Application for a Non-Material Amendment Following a Grant of Planning Permission

Erection of two dwellings with associated parking and landscaping

21/01677

DRAWING TITLE:  
EXISTING AND PROPOSED ELEVATIONS

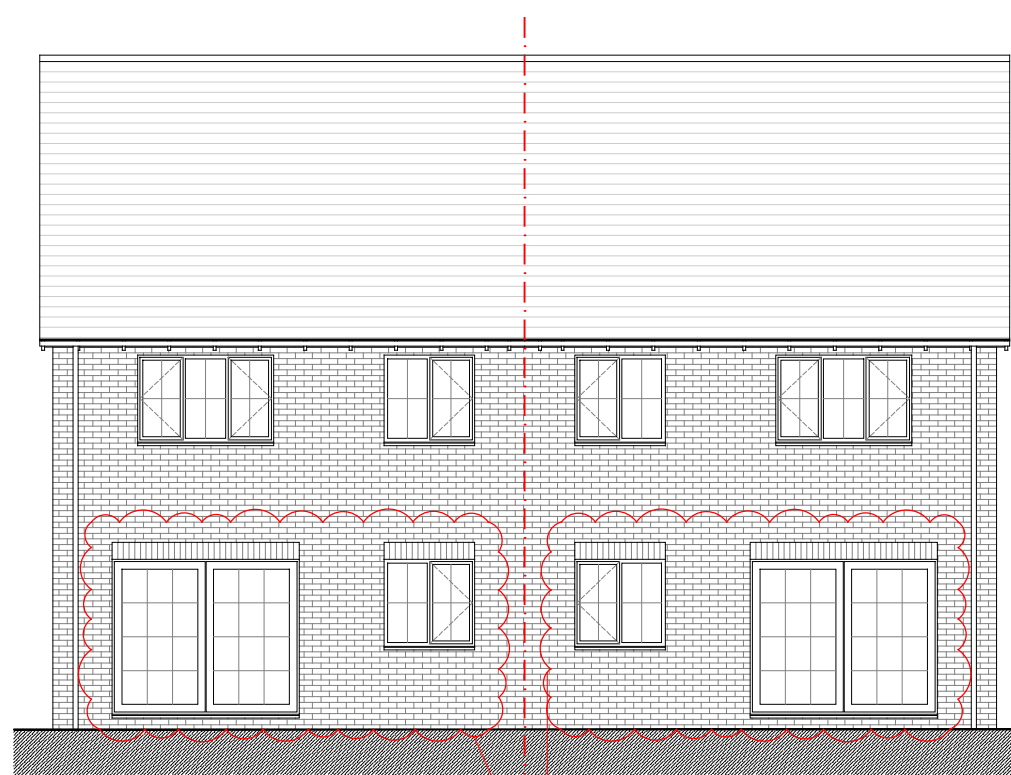
Insertion of small window to WC and switch of rear doors & window to suit internal layout

to suit internal layout
